PLAN REVIEW SHEET

Petition #: RZP 2021-130

Address: 3009 Rozzelles Ferry Road

Request: UR-2 CD

**RZ1.0**

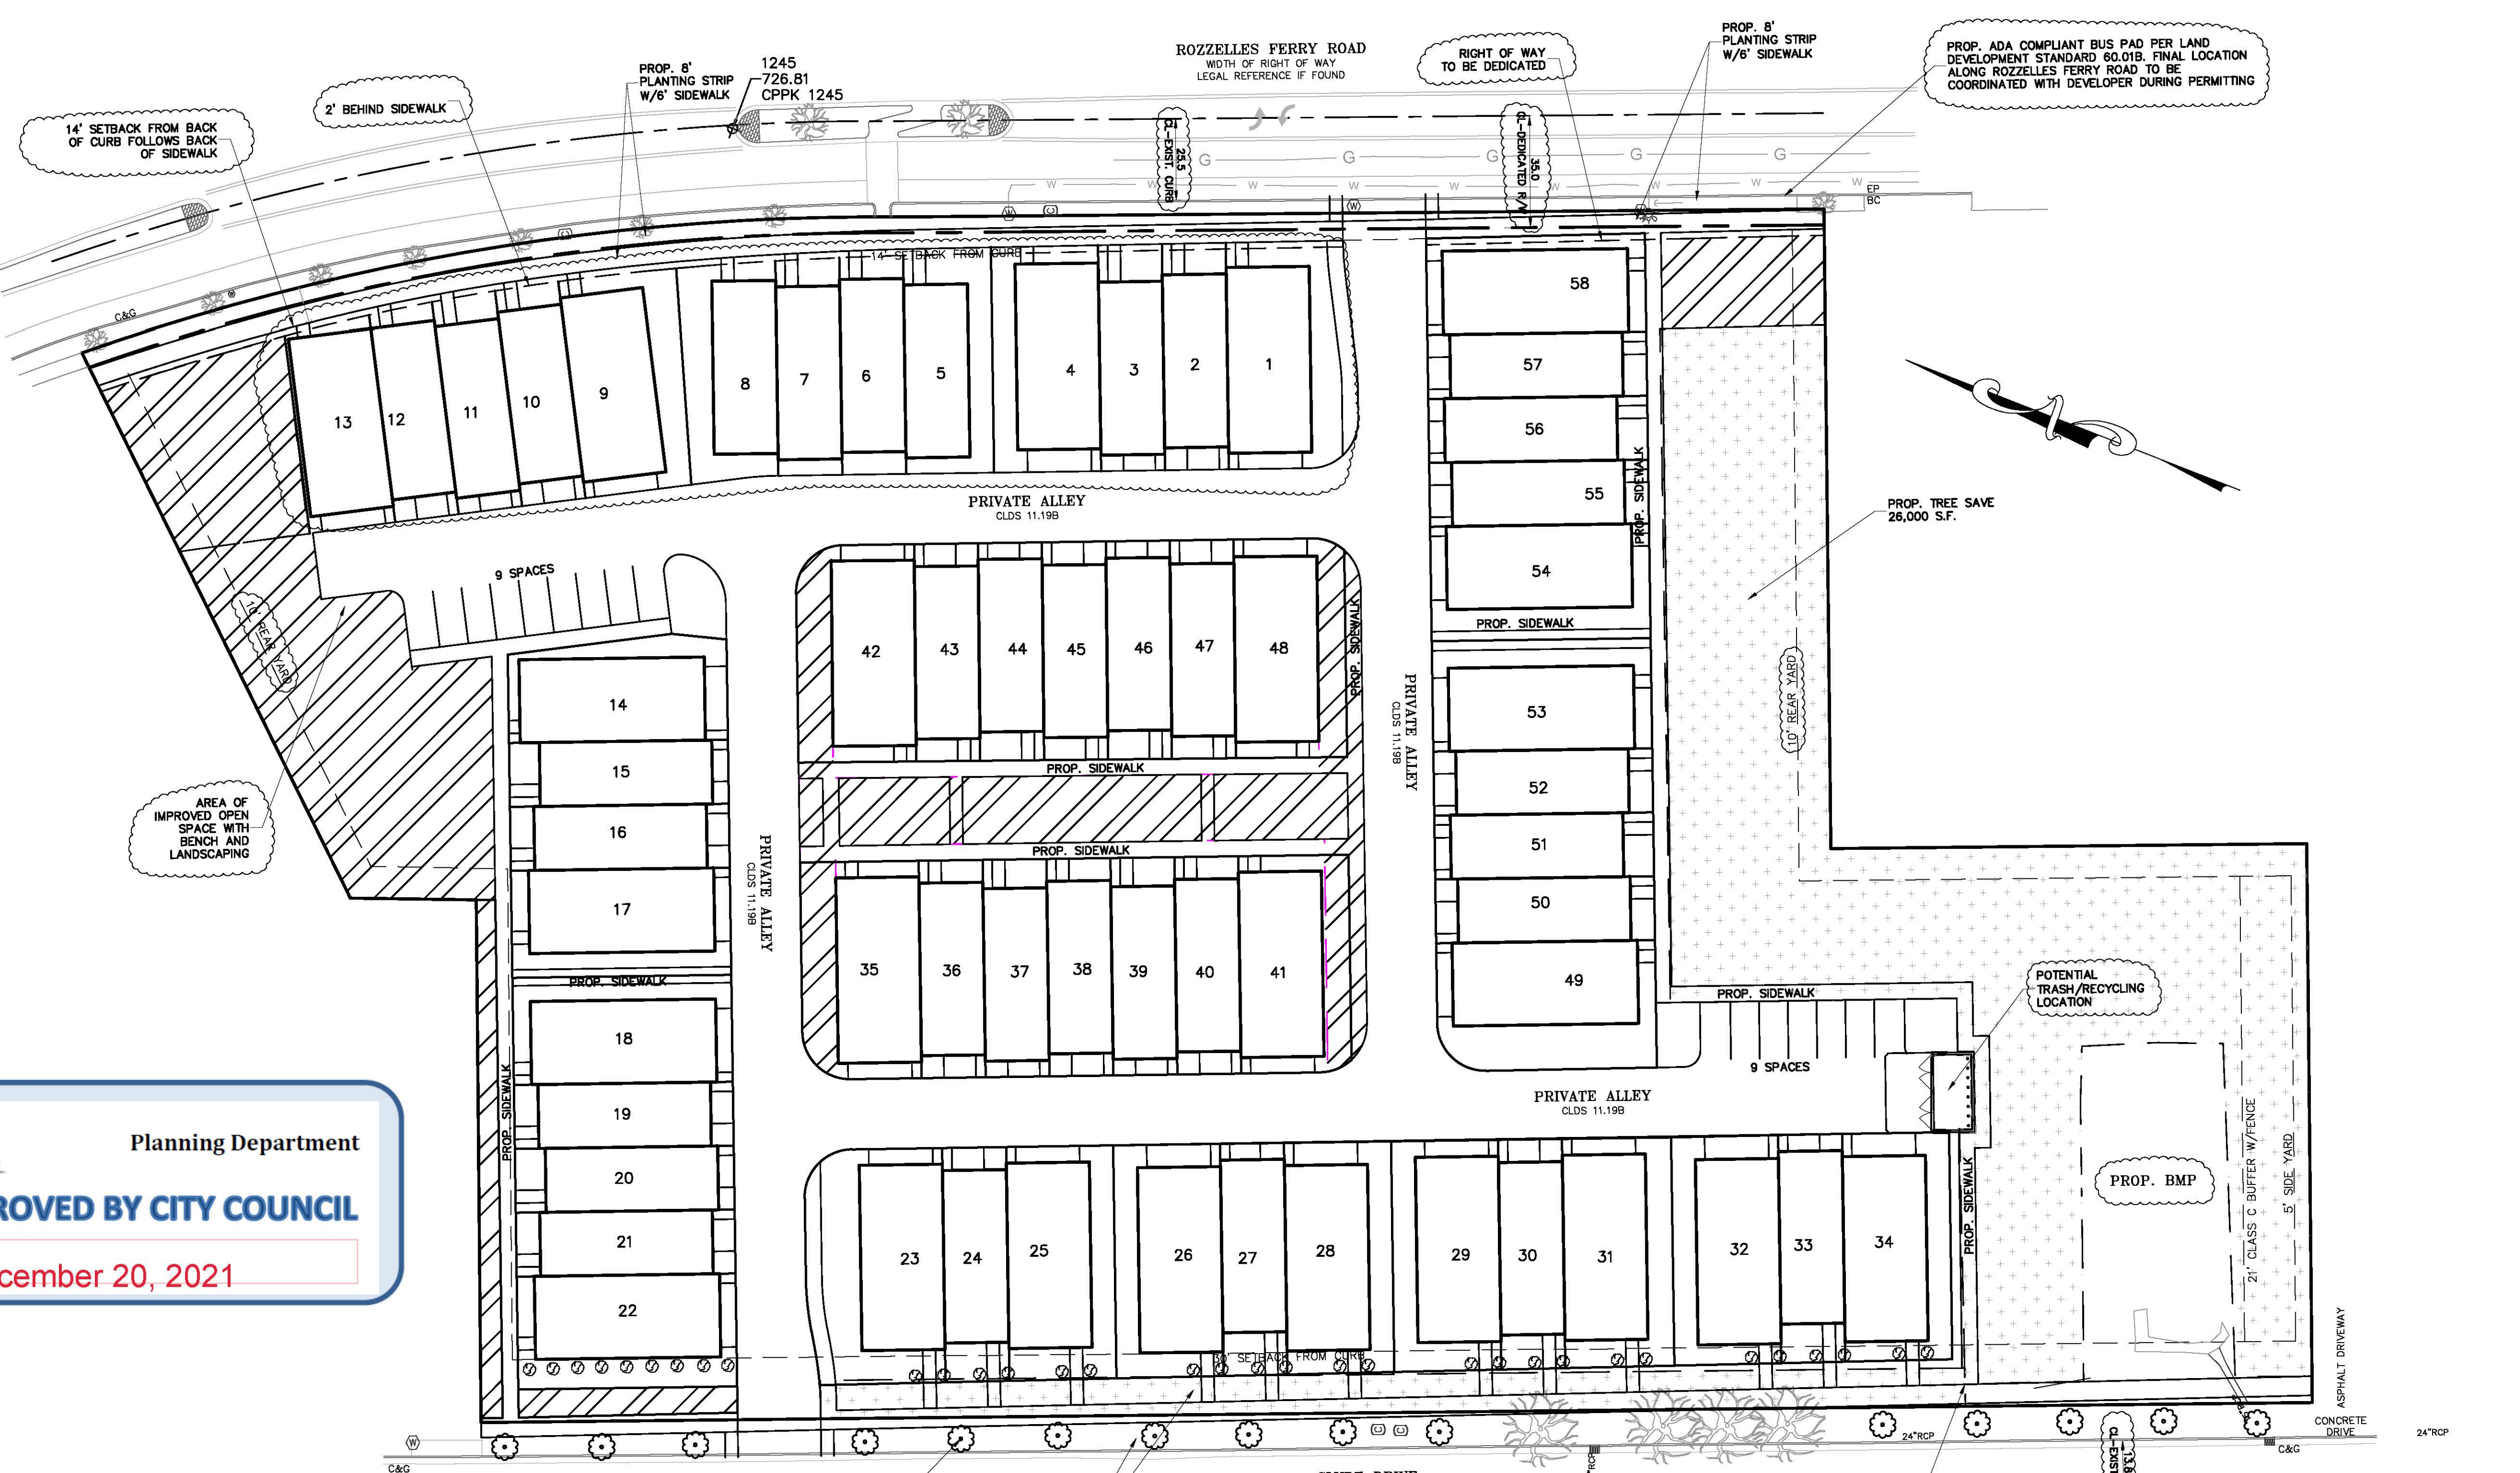
The site is located along CATS local bus route #1 along Rozzelles Ferry Road. CATS requests the construction of an ADA compliant bus pad per Land Development Standard 60.01B along Rozzelles Ferry Rd. The final location of the pads will be coordinated with the developer through the permitting process.
